Date: 10 January 2025
Our ref: Case: 27347 Consultation: 486675
Your ref: EN010115

Five Estuaries Offshore Wind Farm

The following constitutes Natural England's formal statutory response for Examination Deadline 5.

DRAWING TITLE:
Proposed LBBG Compensation Option Area

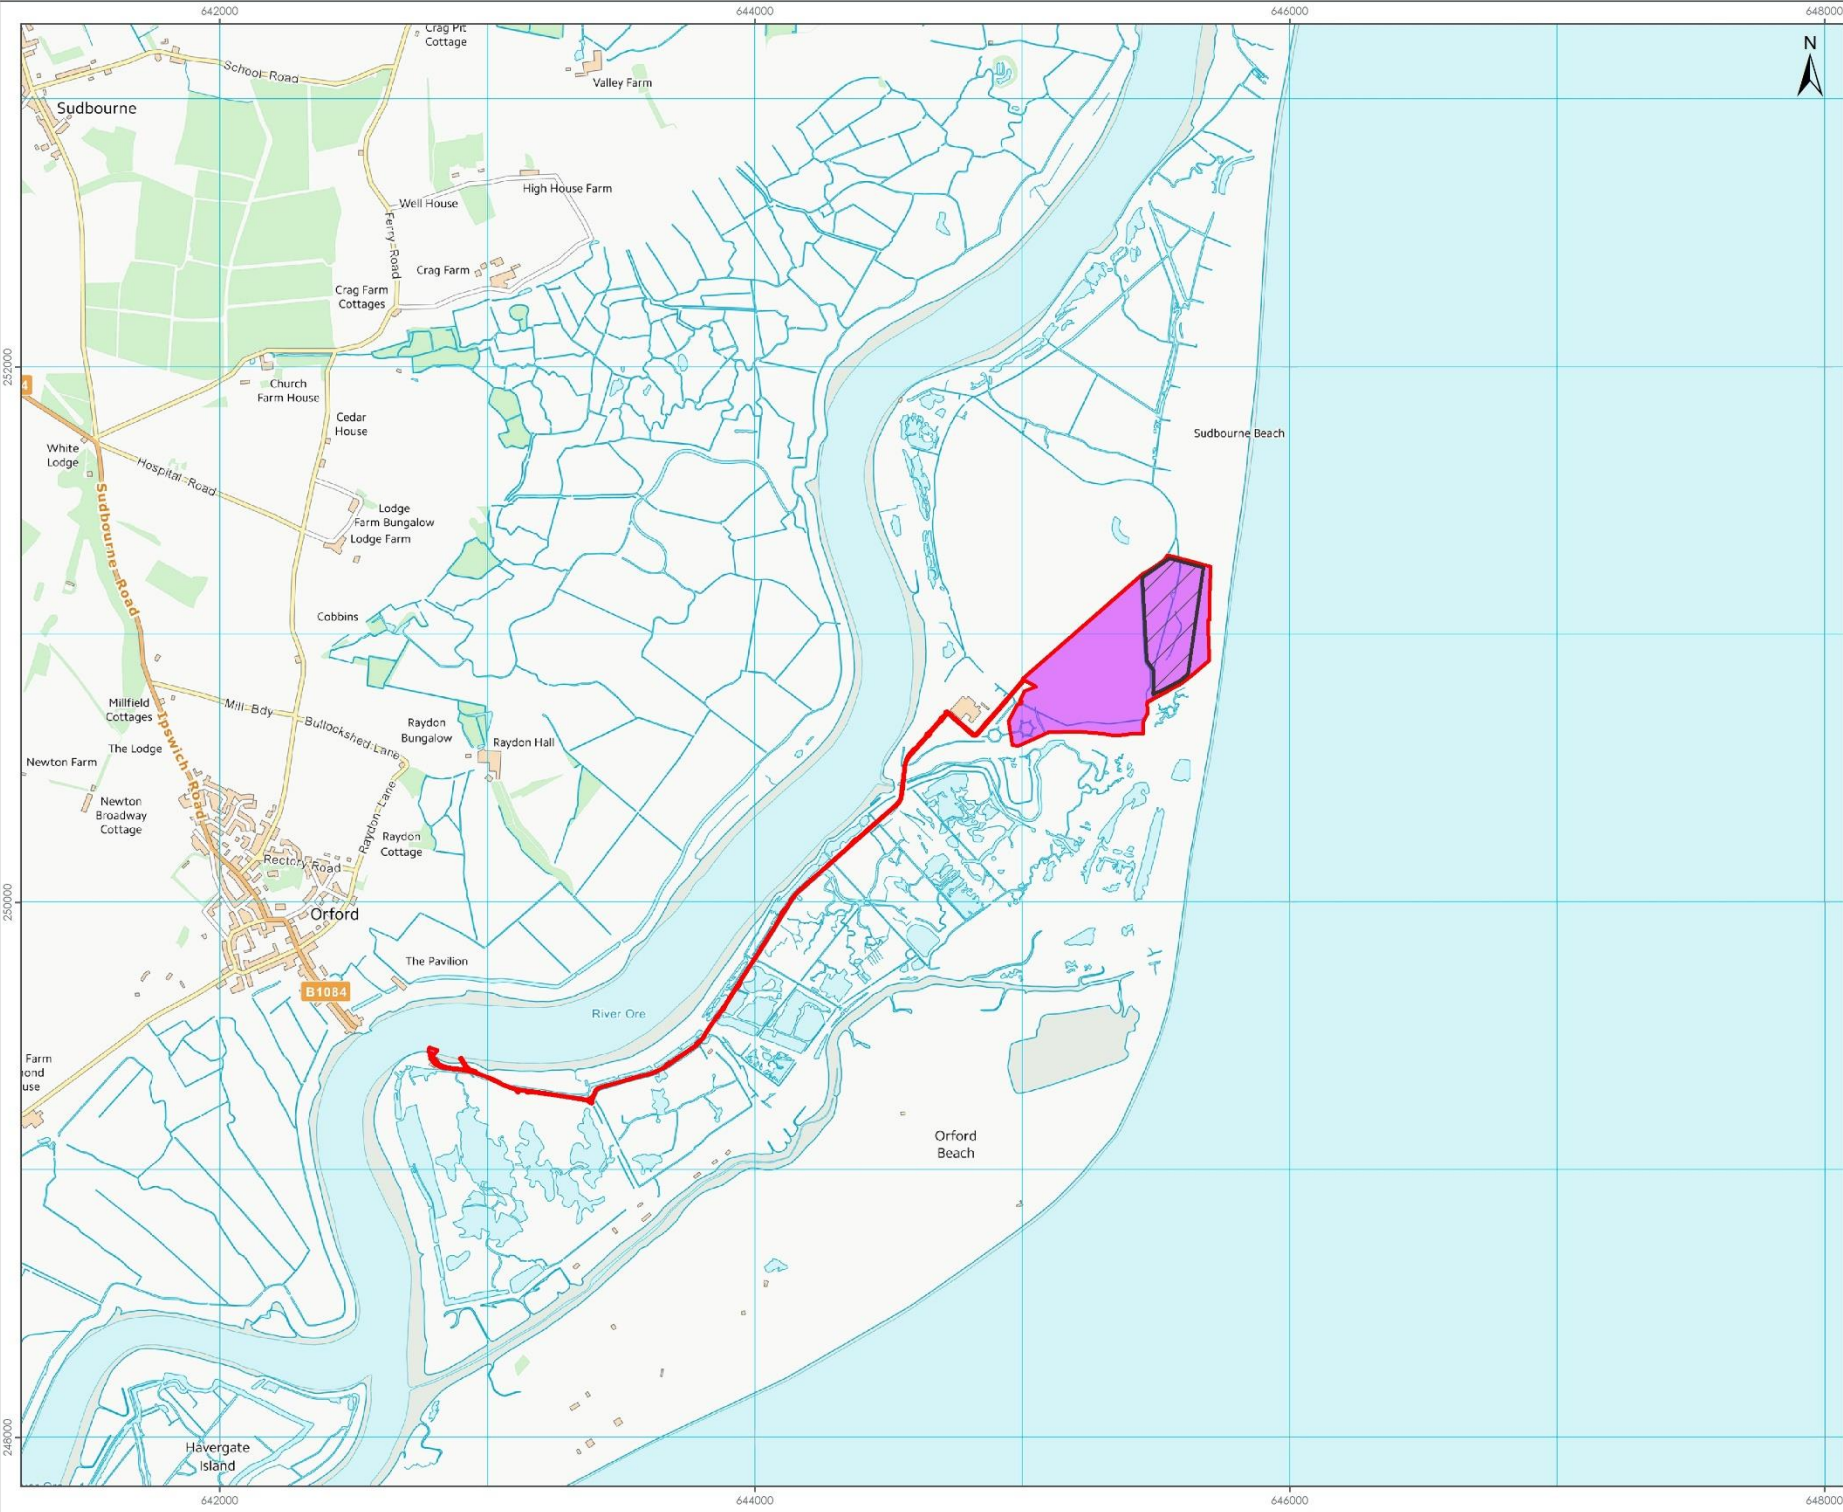
Natural England welcomes the Applicant's 2024 vegetation and invertebrate survey report results from Orford Ness [REP4-042]. However, we note that the area covered by these surveys now lies outside (though immediately adjacent to) the revised proposed LBBG compensation area. We have also reviewed the updated LBBG Habitats Regulations Assessment [REP4-008], LBBG Compensatory Areas Environmental Impact Assessment [REP4-014], and LBBG Ecological Impact Assessment [REP4-016].

The updated LBBG HRA [REP4-008], includes results from the updated surveys. However, these were carried out adjacent to a section of the Proposed Compensation Site (PCS) but not within its boundary or adjacent to the new northern section of the PCS. The northern section of the PCS was not included in the initial surveys (January 2024) or the 'eastern' adjacent surveys (August to October 2024) (Para 2.2.8). Therefore approx. 2.3ha of the PCS have not been formally surveyed at all, including ditch systems. Furthermore, both surveys were carried out at sub-optimal times (Para 2.2.9) and are based on one visit outside the main survey window for flora and fauna.

In the updated LBBG EIA [REP4-014], new areas and amended boundaries have been identified but the baseline data are still absent. We advise that additional information is needed to confirm the conclusions of no significant impact. Our concerns remain unresolved. This also applies to the updated LBBG EcIA [REP4-016]. Lastly, no new information on the proposed ditch crossing has been provided in the EIA as the new survey data do not cover the area impacted.
